A303 Amesbury to Berwick Down

8.2 Statement of Common Ground – The Environment Agency

A303 Amesbury to Berwick Down
Development Consent Order 2019

STATEMENT OF COMMON GROUND – The Environment Agency

NOTES / LEGEND

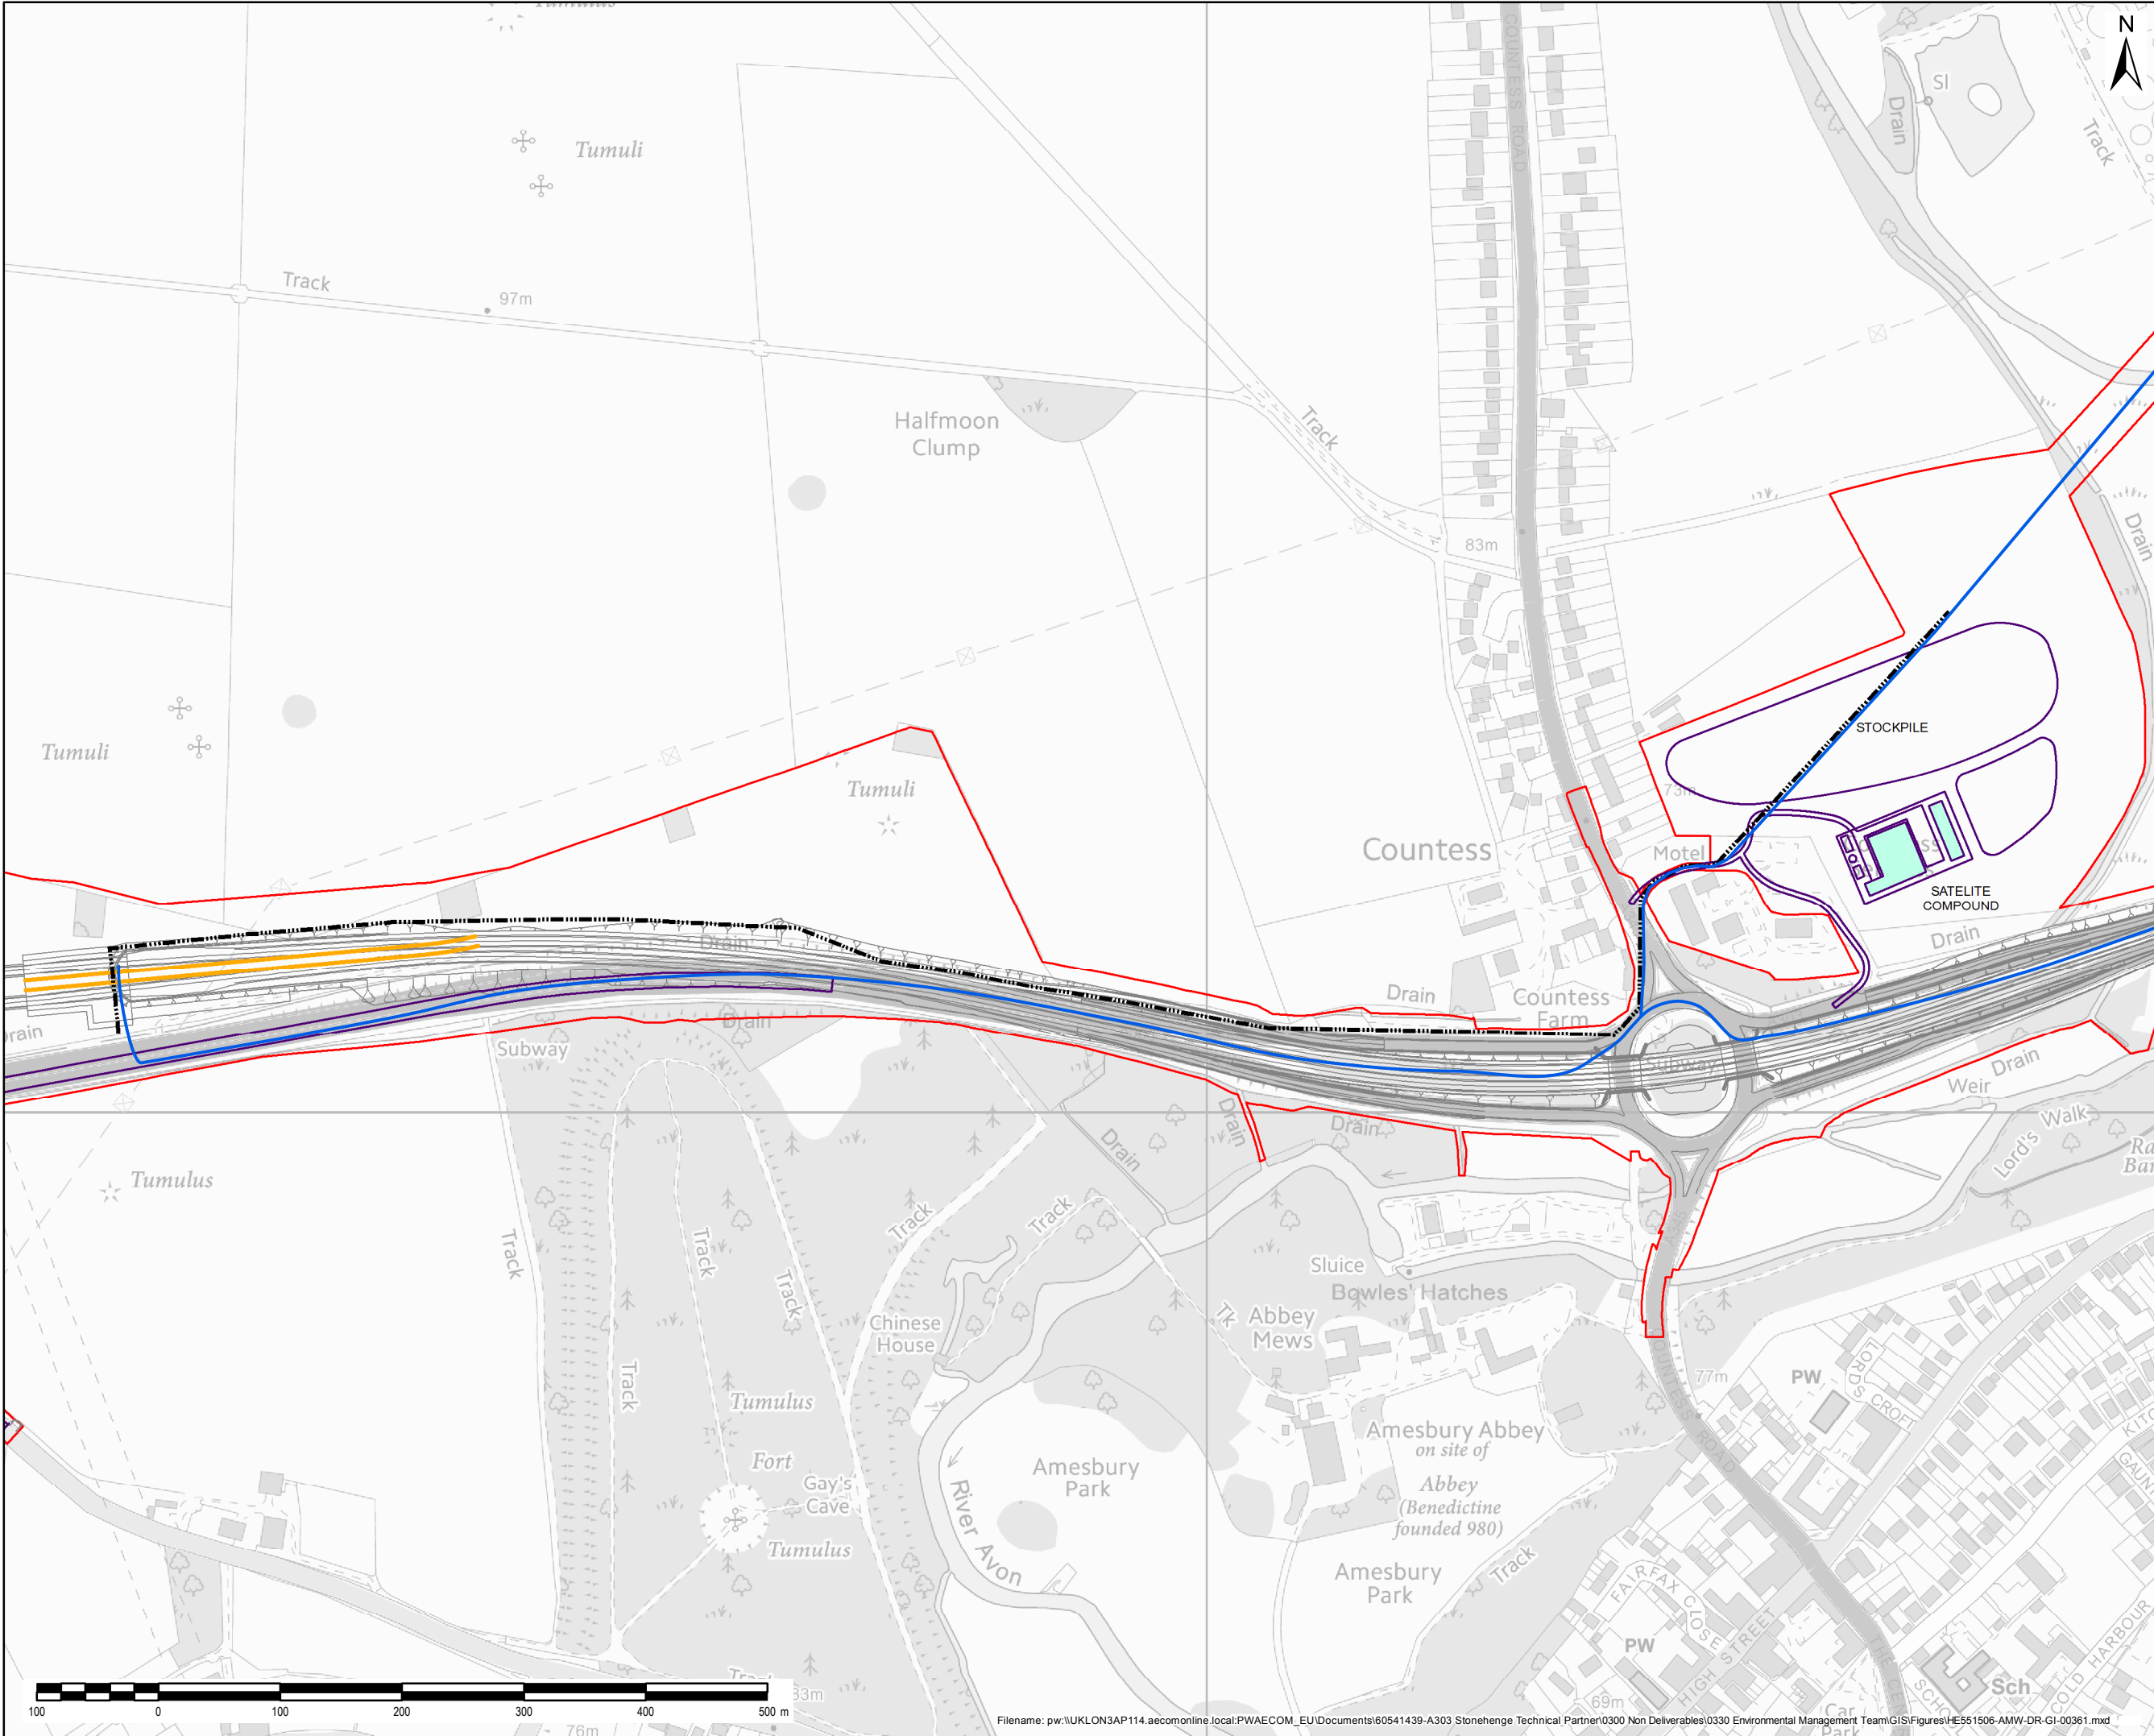
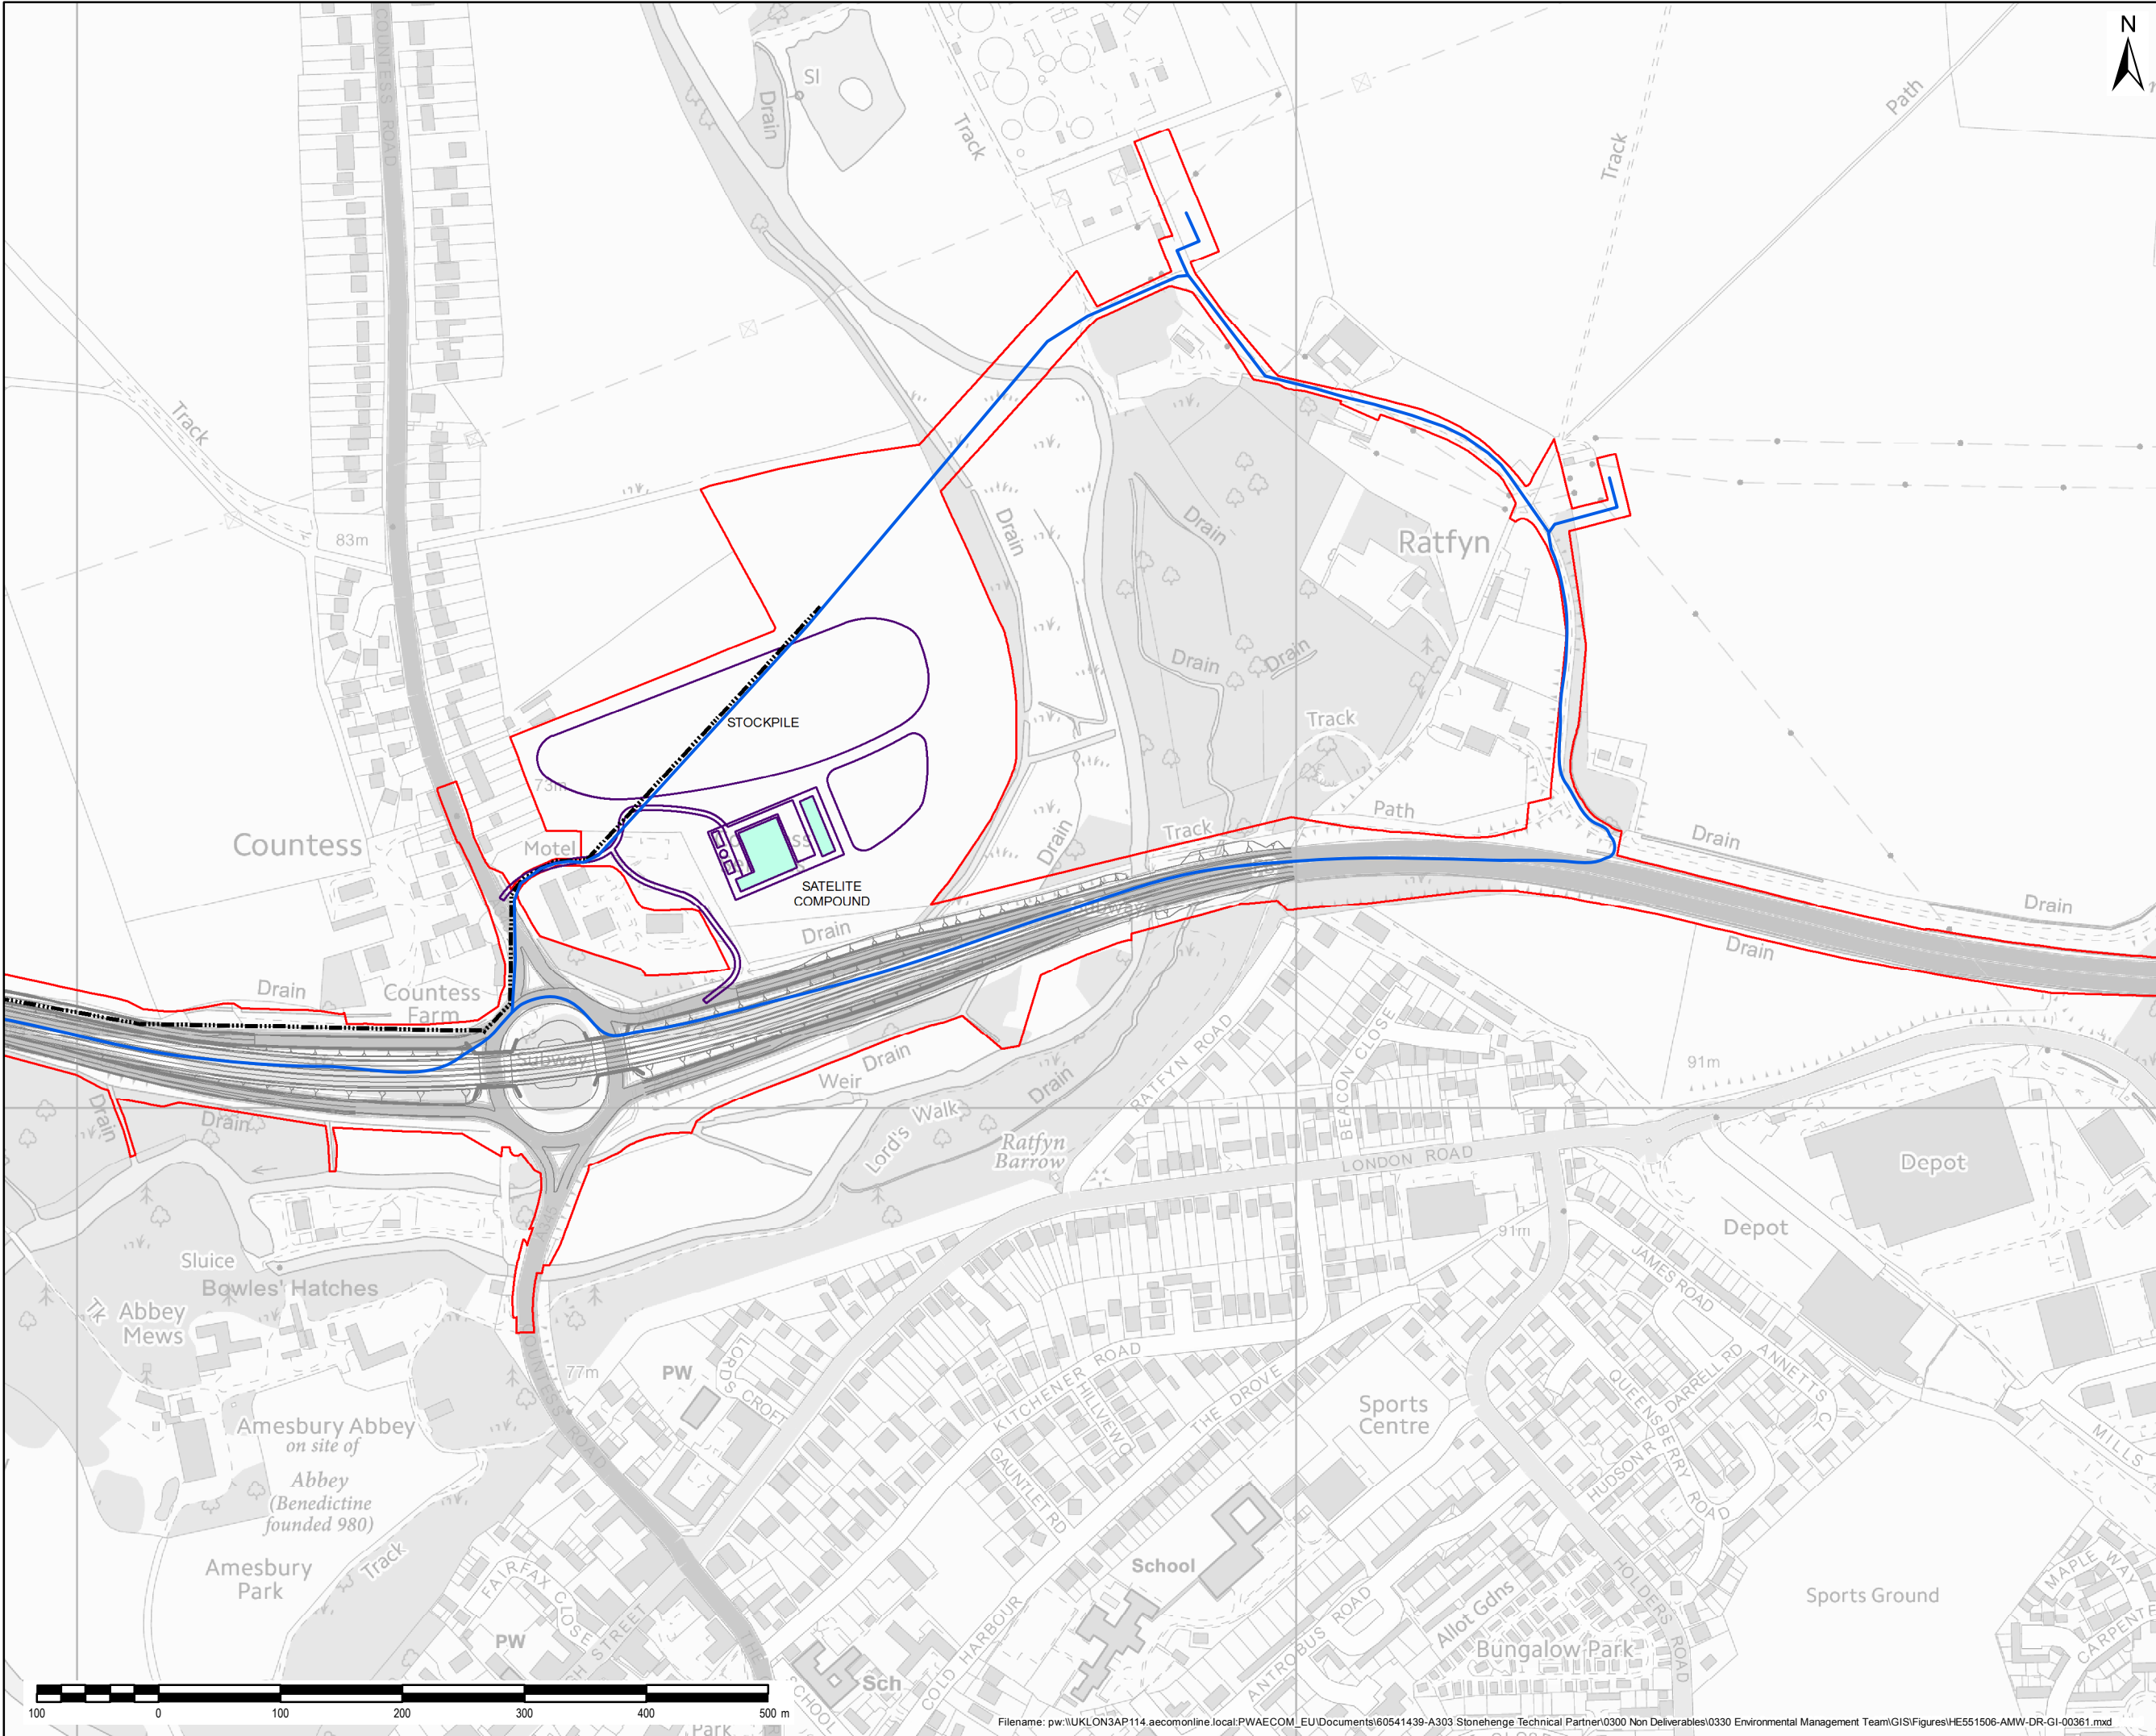
3.25	Flood risk	No temporary soil storage, other construction materials or construction site compounds located within Flood Zone 3 or known locations of high flood risk from surface water or groundwater.	The design of the Scheme locates soil storage, other construction materials and construction site compounds outside of Flood Zone 3 and away from known locations of high flood risk from surface water or groundwater (Figure 2.7 of the ES, APP-061).

Figure 4.1: Tunnel Drainage Schematic

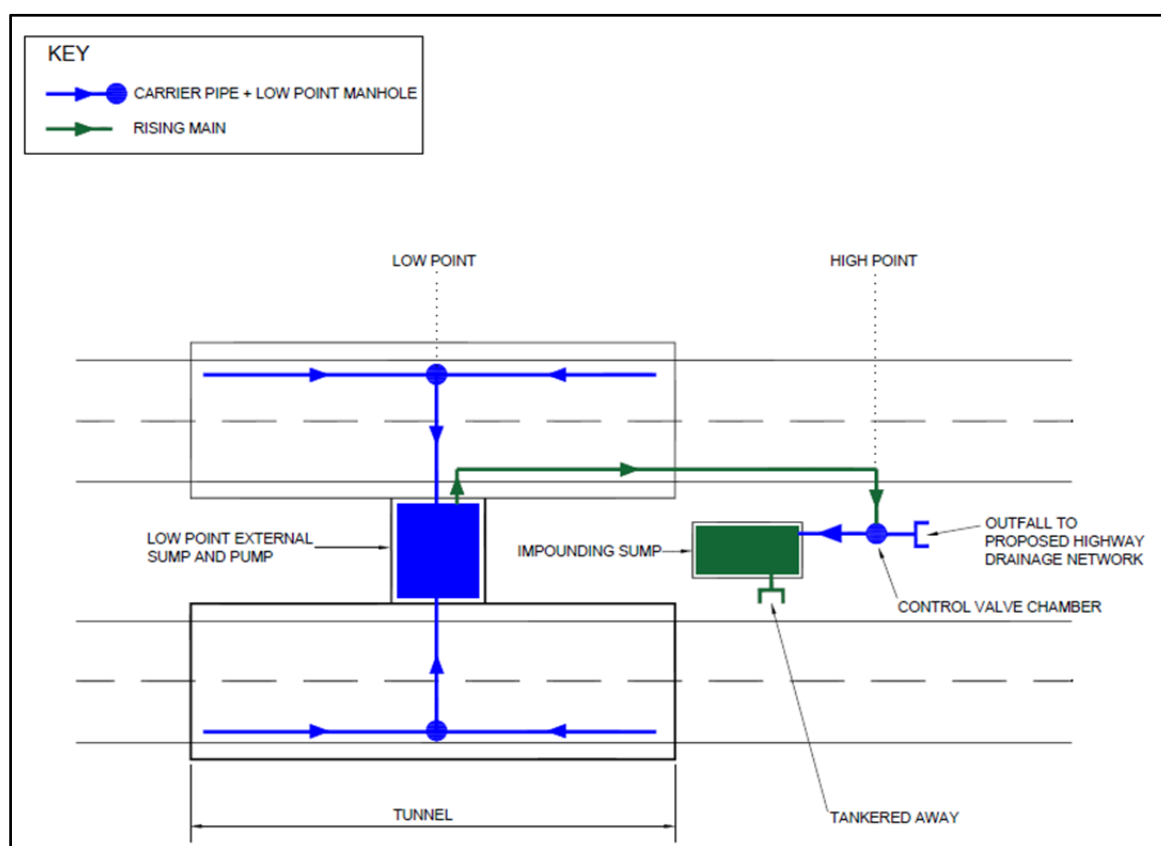
3.19	Groundwater	The EA request further clarity on the likelihood and nature of any temporary dewatering required for tunnel construction and that the assessment of risk and identification of any required mitigation	Any need for dewatering will be minimised as far as reasonably practicable. The current proposal is to use tunnel construction techniques (such as the use of Tunnel Boring Machines) that limit the requirement for dewatering

<p>measures be repeated if it is confirmed that dewatering will be required.</p> <p>The Environment Agency will not agree to the disapplication of legislation in respect of this activity and therefore HE will need to rely on an exemption or apply for a licence/permit if needed.</p>	<p>during construction. The assessment of risk and identification of any required mitigation measures will be achieved through the OEMP (MW-WAT8) and whichever regulatory regime is ultimately agreed, i.e. either the Environment Agency's permitting regime or protective provisions within the DCO, if it is confirmed that dewatering will be required.</p>
